Planning Application Ref: AL/16/18/T

Location: 16 Woodgate Road, Woodgate, Aldingbourne

Description of works: 3m Crown Reduction and 30% Crown Thinning to 1No. Hawthorn & 2No. English Oak trees

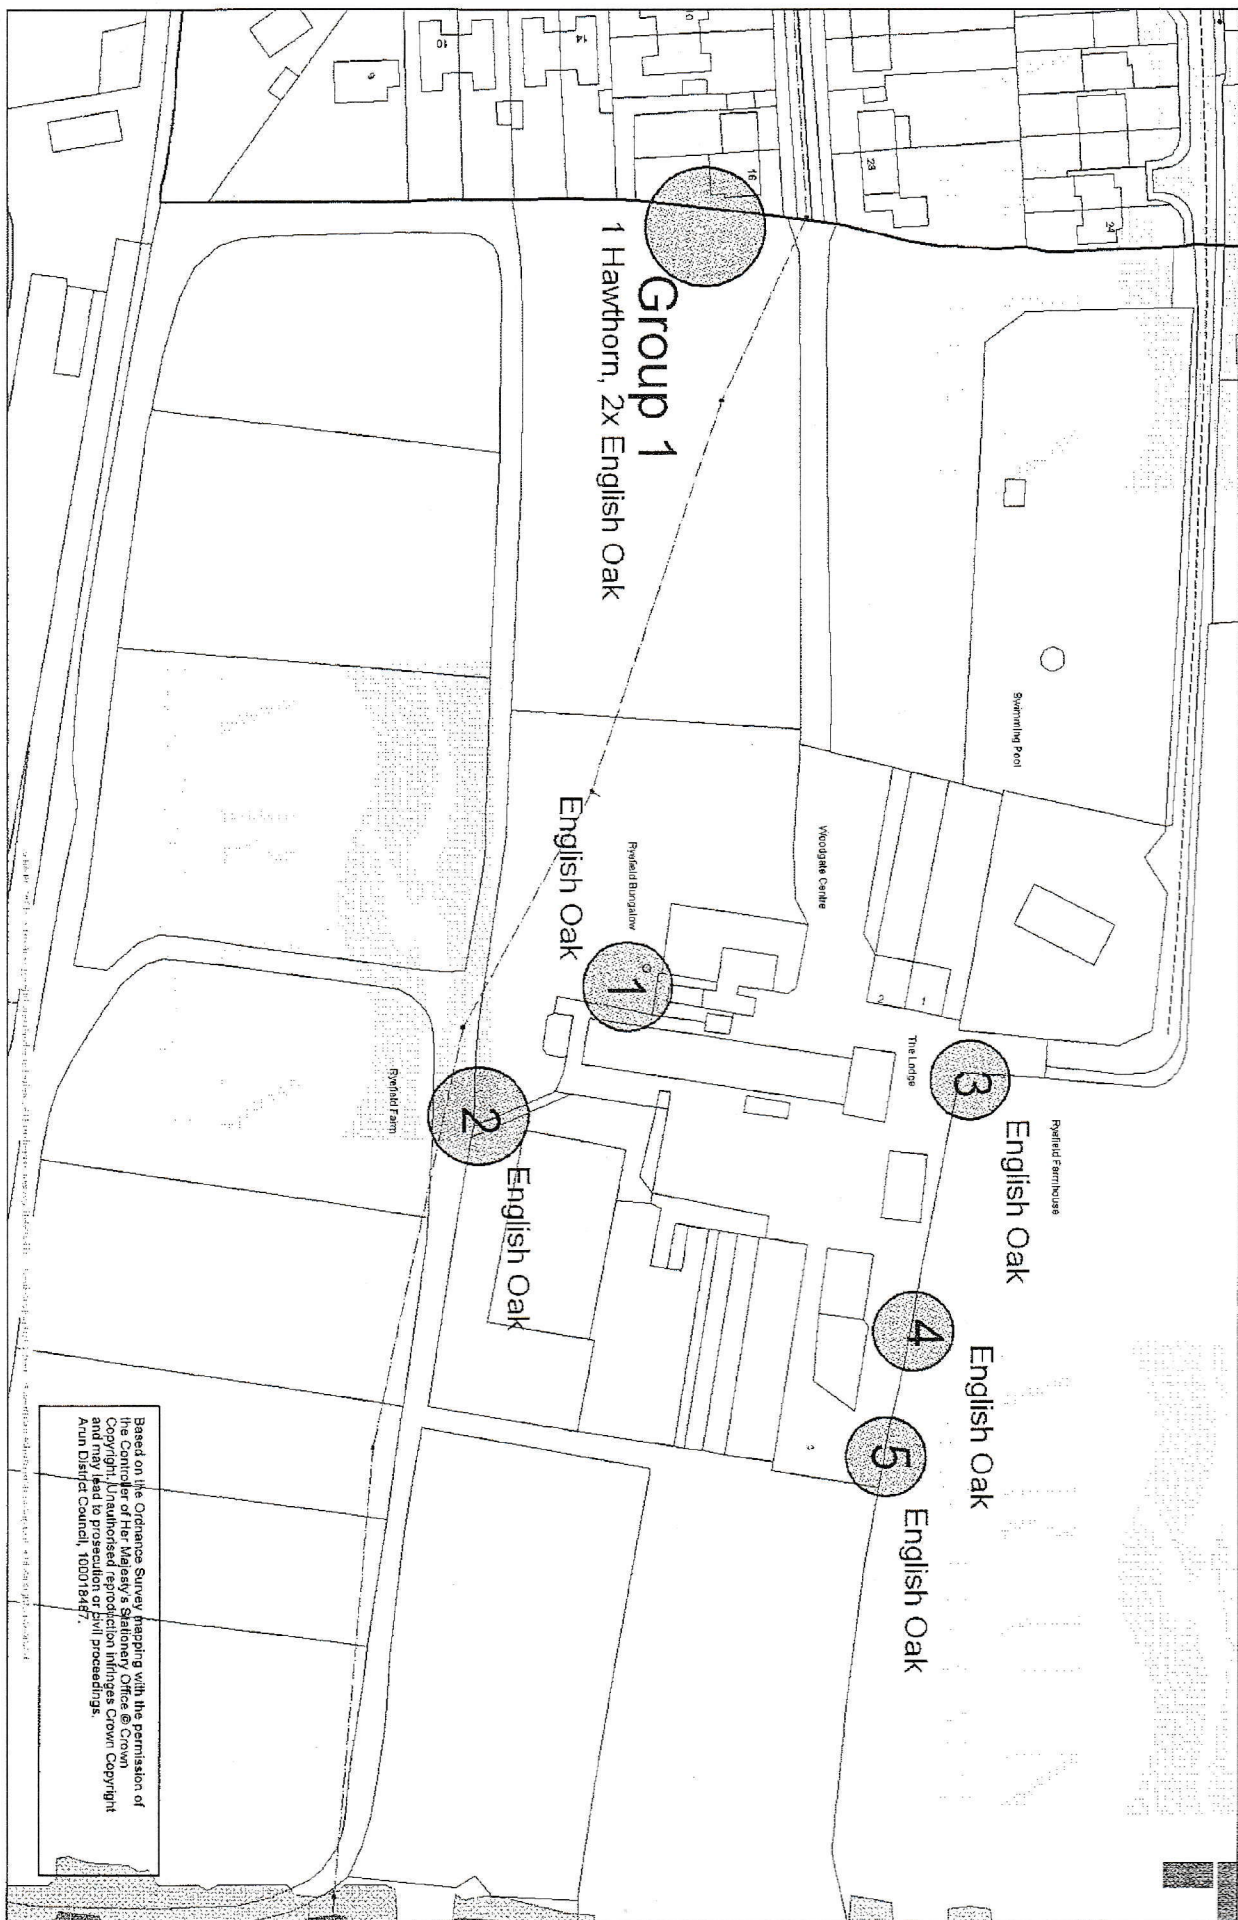
- These are fine examples of their type and visible from the adjacent public highway and neighbouring properties; thereby providing a notable visual amenity.
- In respect of the oak, they have good form arising from a lack of significant crown modification and with an open field aspect permitting the establishment of low branches. Although not comprehensively assessed, they appear to be in a fine physiological state and free of significant structural defect. As old field boundary trees they possess considerable landscape value.
- The oak are closely spaced to one another with a shared crown profile. Their relatively short distance to the main building has inevitably caused an intensely shade-bearing and oppressive effect with large branches travelling across and in close proximity to the roof and east flank wall.

- *Crown reduction* and *Crown thinning* work has not been justified on arboricultural grounds. In respect of the latter, such work rarely provides a benefit to the tree and often only a short-term increase in light levels. Furthermore, combining the two operations (and especially to the extent proposed) could drastically alter tree dynamics and natural defences against wind pressure. The sudden exposure of central crown areas to such winds can result in significant damage.
- These trees are a significant feature in the local landscape and appear to be in adequately sound and healthy condition. The tree surgery proposed in the application would result in excessive reduction of the tree's landscape impact and undue detriment to the visual amenities of the locality.

- I recommend **REFUSAL** for this application.

- I would like to see the applicant re-submit with a revised work specification such as detailed below, which would address the issue of direct building interference and help improve conditions along this side of the dwelling whilst preventing a diminution of the tree's landscape and public amenity value:

2x Oak

- Reduce or remove branches as necessary to achieve a maximum of 2m building clearance.

- Reduce or remove branches as necessary to achieve a maximum of 4m overhead clearance above side of property (driveway and garden areas).

Hawthorn

- Reduce or remove branches as necessary to achieve a maximum of 3m overhead clearance above driveway.
